**Response to the Applicant's Deadline 6 submissions,  
The Examining Authority's Report on the Implications for  
European Sites and Deadline 7 submissions**

**Royal Society for the Protection of Birds**

**Application by North Falls Offshore Wind Farm Limited for an Order  
Granting Development Consent for the North Falls Offshore Wind Farm**

**Planning Inspectorate Ref: EN010119**

Figure 3 LBBG Compensation short-listed sites at the AOE SPA LBBG search area

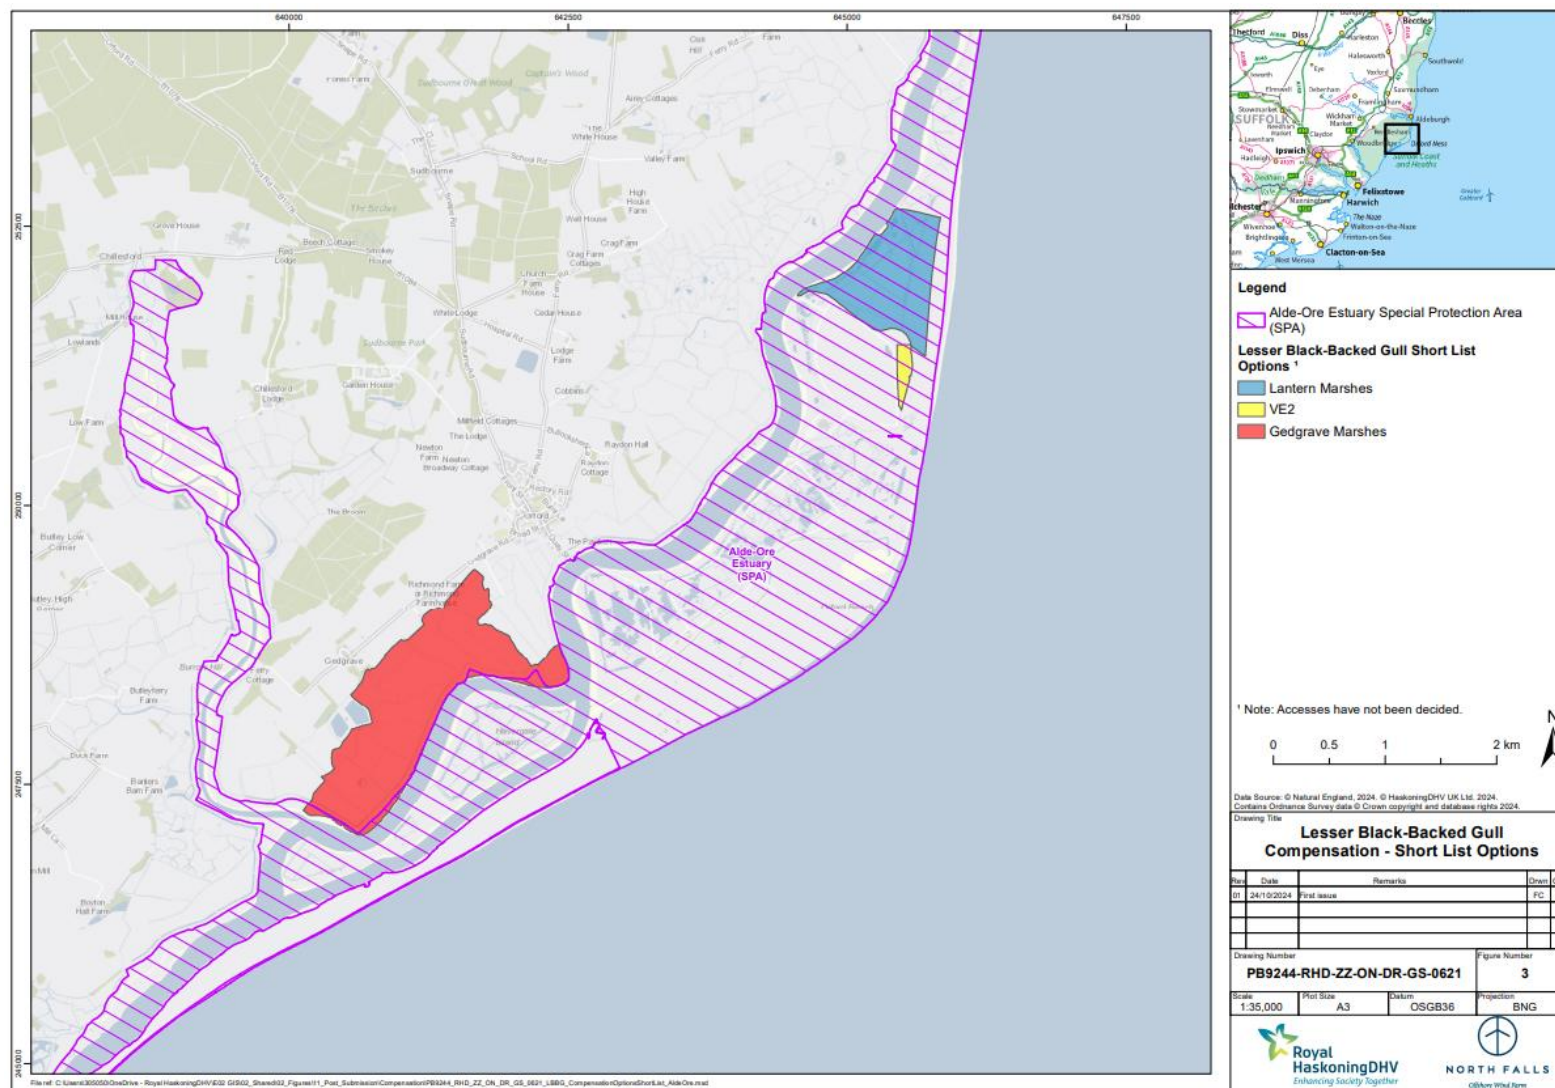
- 2.3. Section 8.2 of REP6-012 presents the short-listed compensation sites discussing Lantern Marshes, Gedgrave Marshes, the proposed Five Estuaries compensation site ('VE2') and Outer Trial Bank. Since submission National Trust has withdrawn from discussions on Lantern Marshes (see Section 4 below), leaving the three alternative options. The RSPB has discussed these options in an earlier submission (REP4-089). These comments remain valid. The RSPB also met recently with the Applicant specifically to discuss the Gedgrave Marshes option.
